From: Sian Eggington
Sent: 03 December 2018 11:44
To: [REDACTED]
Subject: AW/338/18/HH

15 Willowhale Avenue - 2208.18

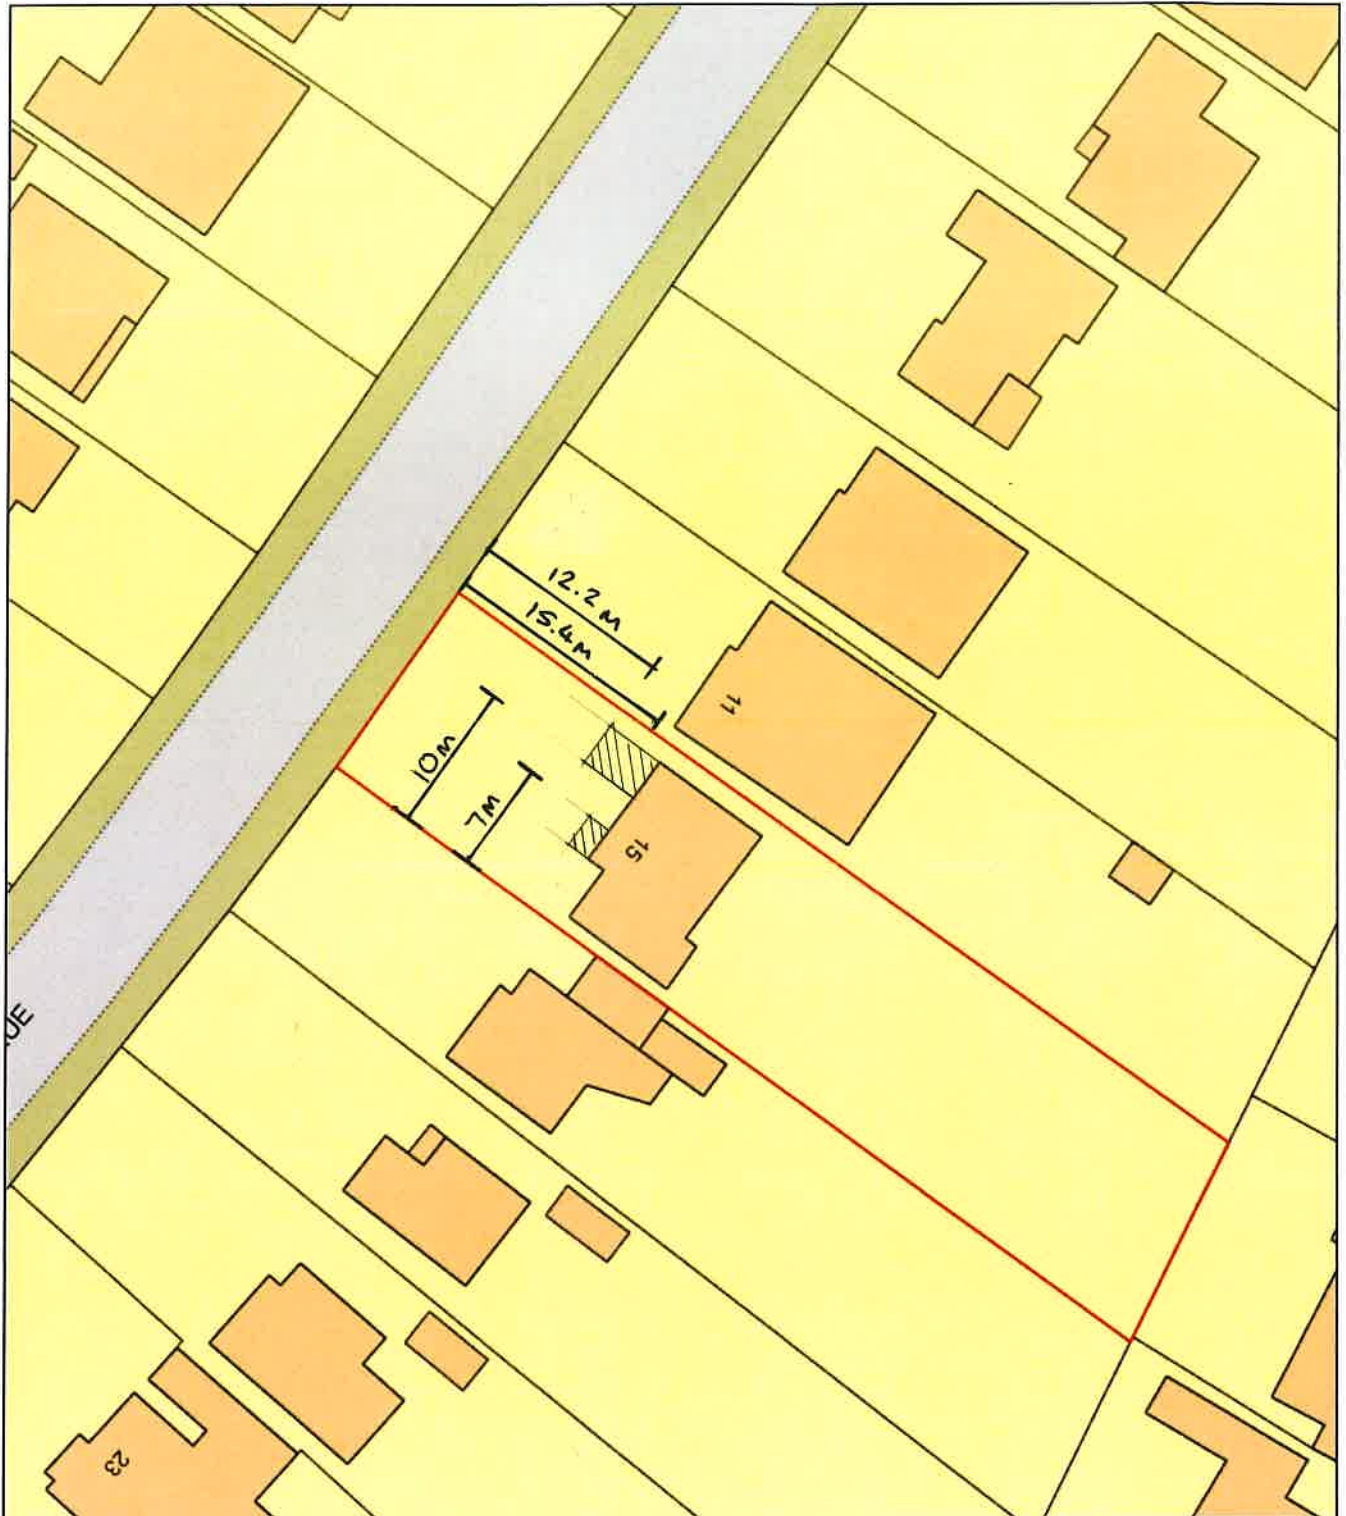
Thank you for your email. However please could you add a similar dimension from the proposed extensions to the front boundary. Once received I'm happy to make this application valid and upload it straight away for you.
